We have received the proposed Range Short Plat, located in Section 32, Township 19, Range 18, off of Lower Green Canyon Road. We have also received the \$376.88 plat submission fee (receipt #49743 & 49746).

TO: Mary Rill, Community Development Services
FROM: Christina Wollman, Planner II *w*
DATE: March 7, 2007
SUBJECT: Wilson, Range, Sage and Richard Short Plats

RE: Range Short Plat, File #SP-07-13

RANGE SHORT PLAT

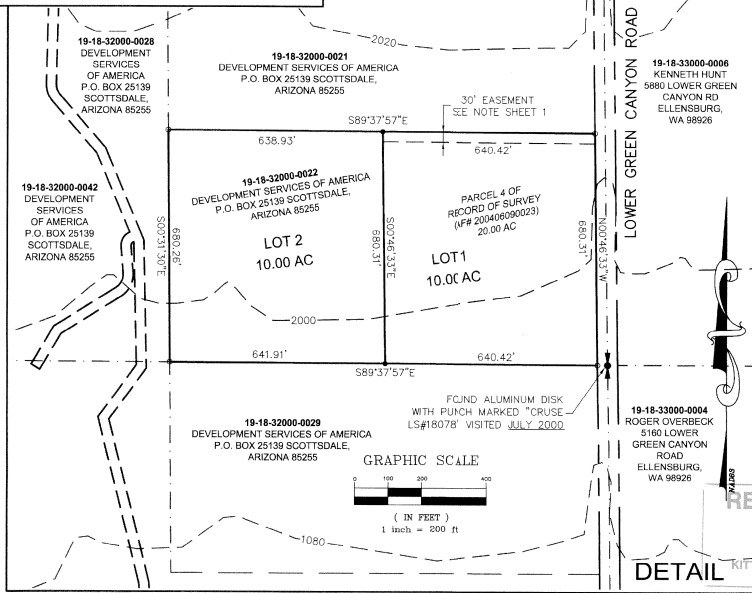
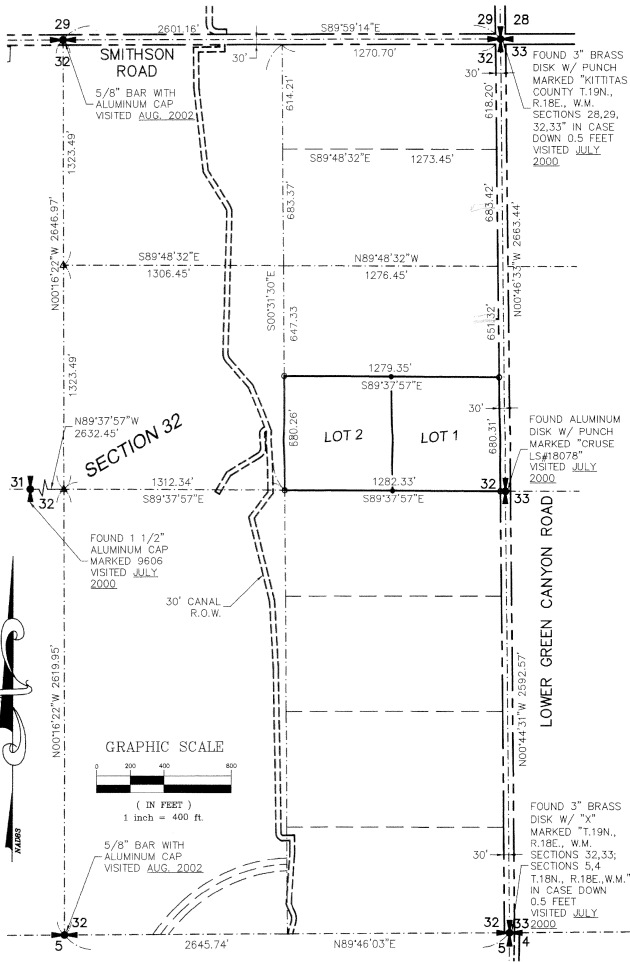
4. Driveway Access for Range Short Plat: Lots 1 and 2 will be accessed by the 30' easement shown on the plat. At a minimum, a joint-use driveway must be constructed at this location. Kittitas County Road Standards for this driveway type are shown above in comment #3.

6. Plat Notes: Plat notes for each short plat shall reflect the following:
- a. Plat note #3 is incorrect and shall be removed.
 - b. Maintenance of the access is the responsibility of the property owners who benefit from its use.
